From: Anita Gardner
Sent: 07 September 2020 10:06
To: Planning.Responses
Subject: FW: Objection CM/25/20/PL

Please see a letter of rep I have received today from James Baird regarding the proposed flood defence works at Climping Mill. Can you let me have your comments in relation to the paragraphs in respect of flooding?

Location Plan
CM_location plan
Scale: 1:1500 @ A1
Date: 16.06.2020

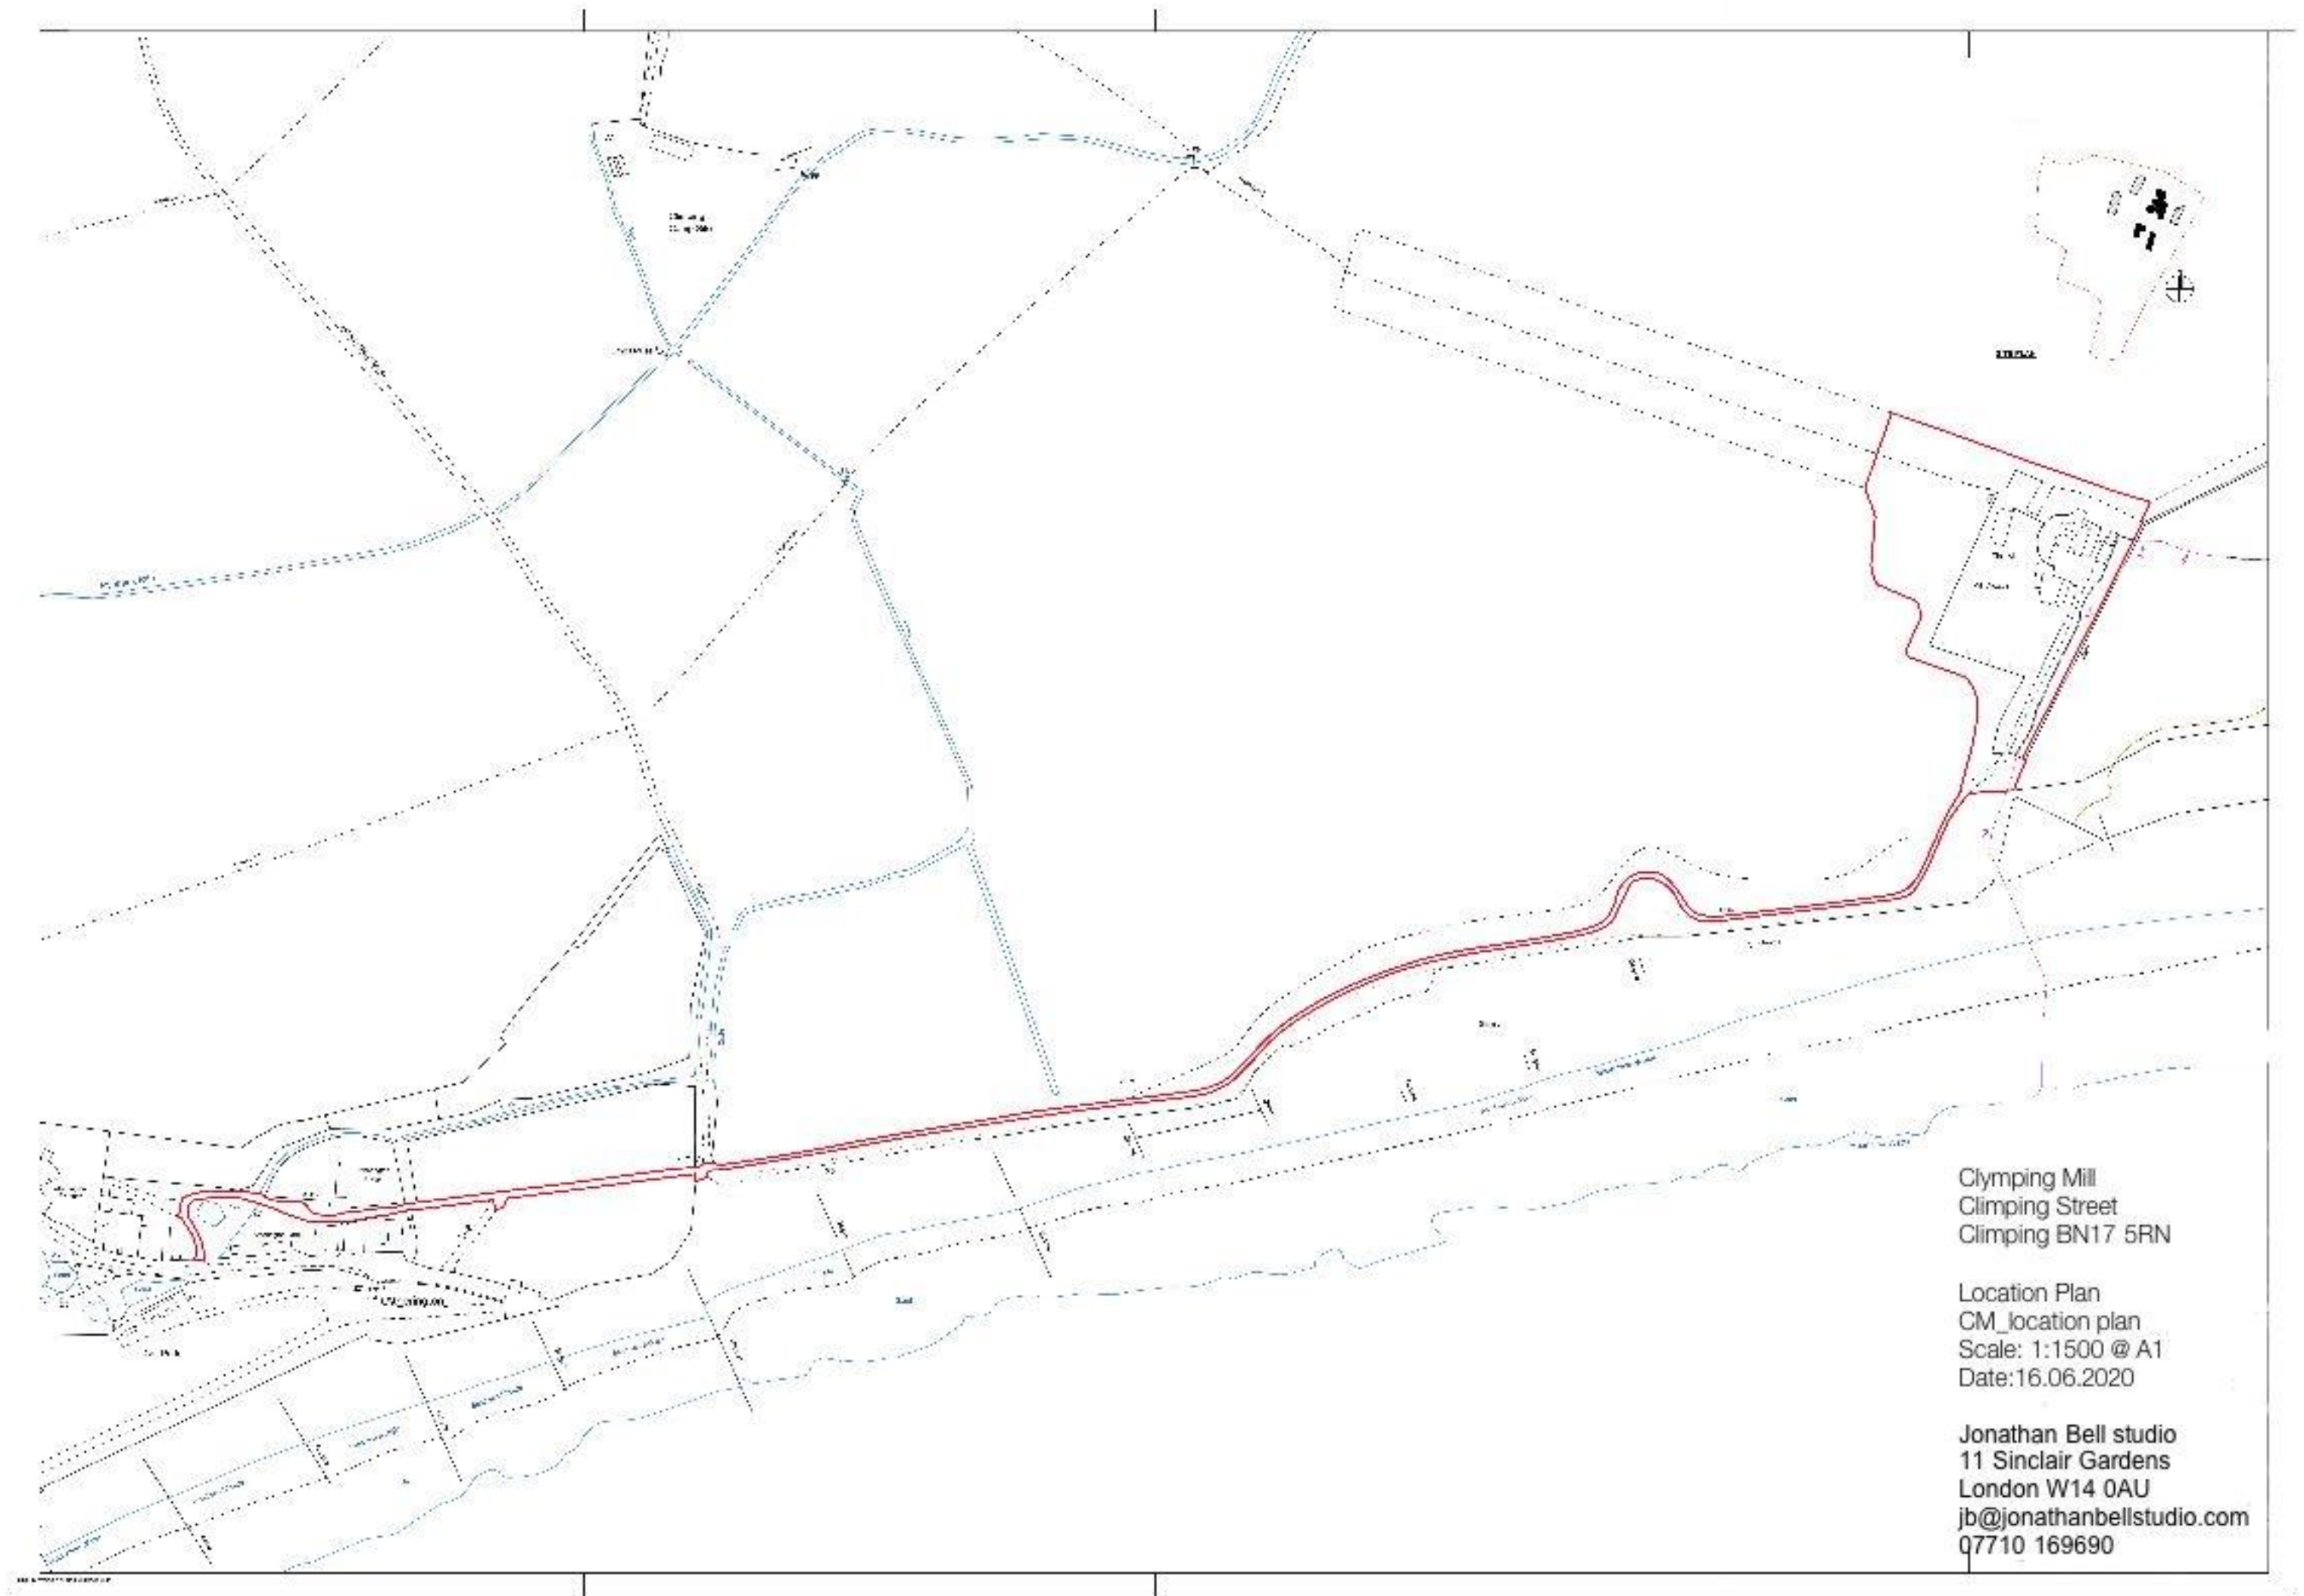
I am not sure why the Applicant has edged the access road red on the Location Plan – it would seem that none of his works are proposed there. Edging this red leads to the issue of Mr Baird having been served a Notice. I wouldn't have thought this necessary as the Applicant, on the Block Plan, asserts that he owns all of the site area (ie the red line is within the blue line).
